Application for a Non-Material Amendment Following a Grant of Planning Permission

Erection of single storey flat roof extension to rear and double garage to front of dwelling

23/0197/HOUS

Wrought iron spiral staircase added to north elevation of the double garage.

Dwg No: 223029-05A  
Scale: 1:50  
Date: 11/22

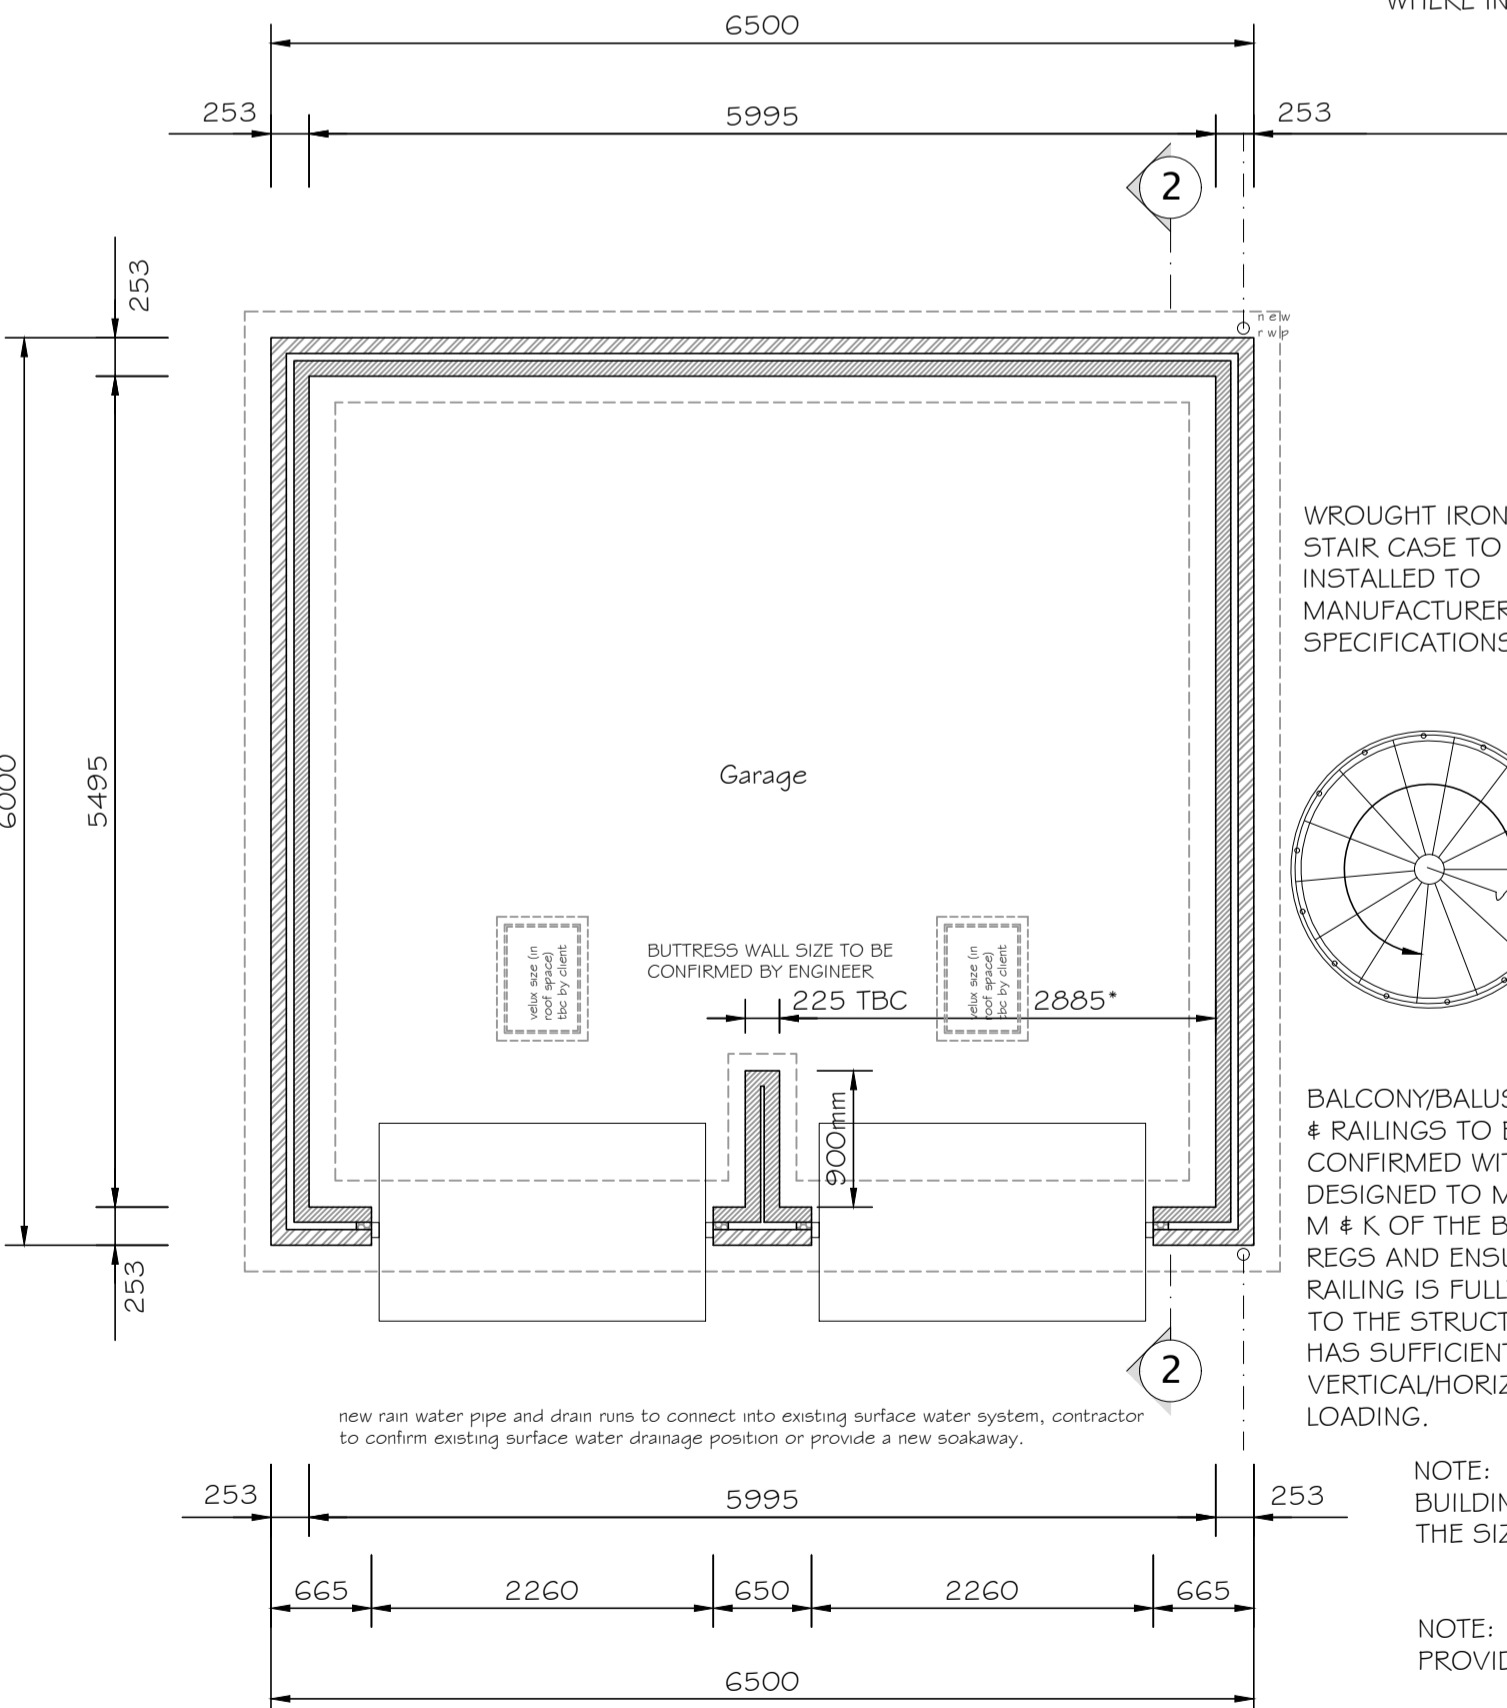
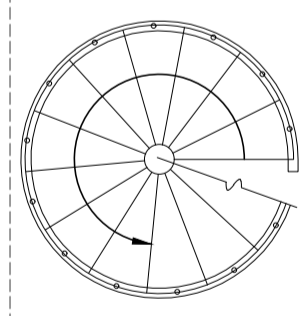
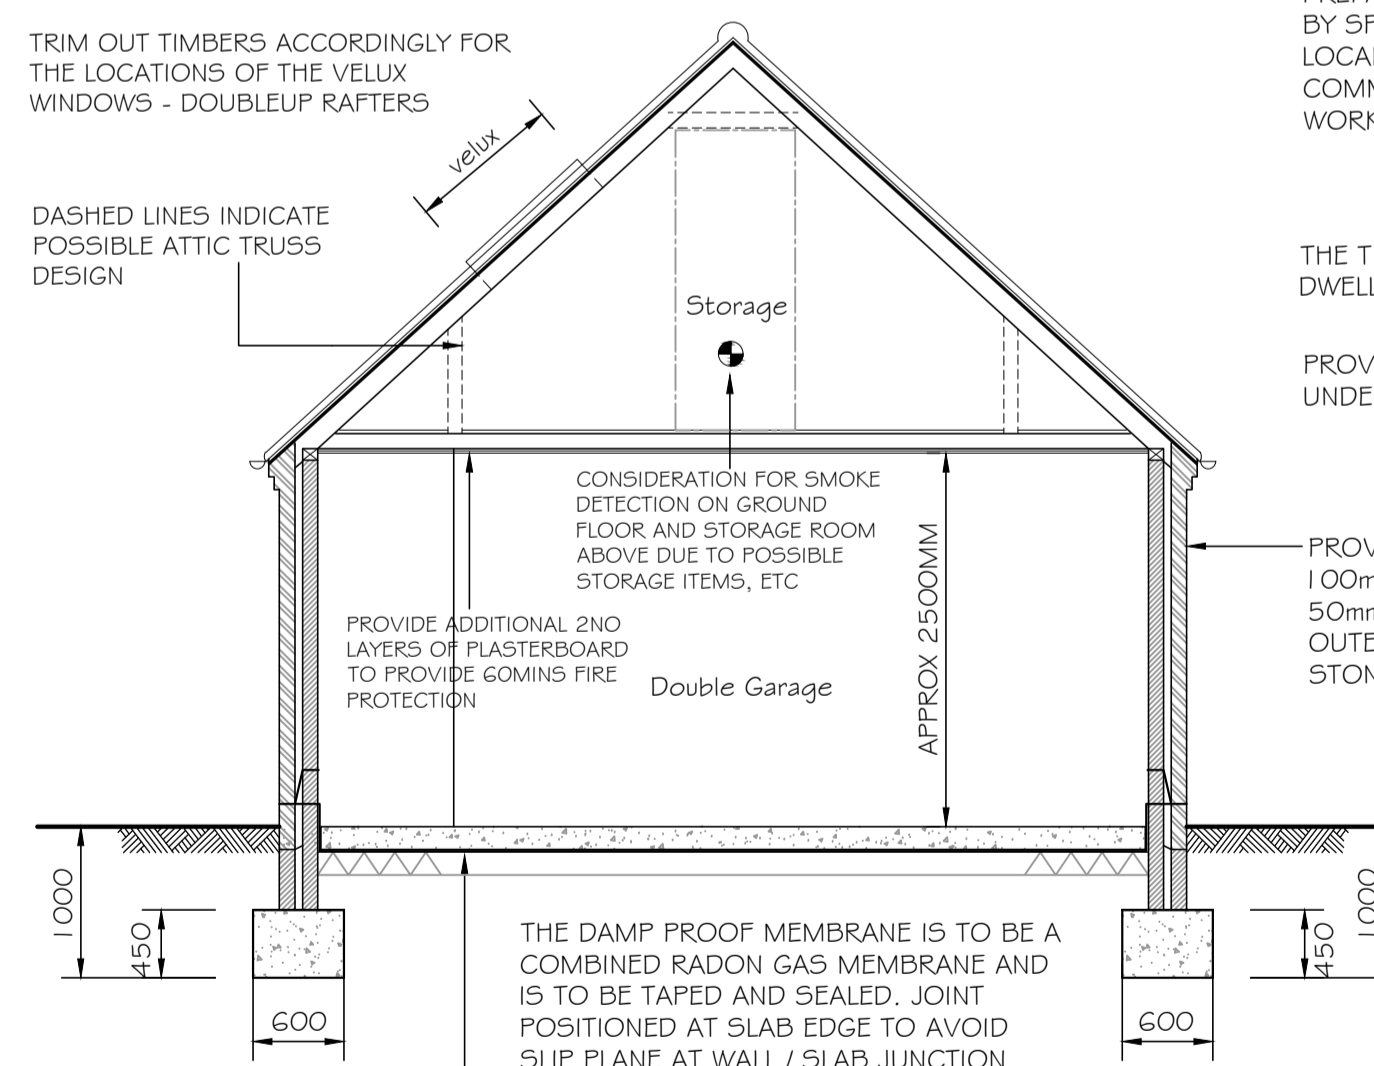
Personnel door added at 1.5 storey level to provide access to roof space, personnel door removed from ground level as no longer required.
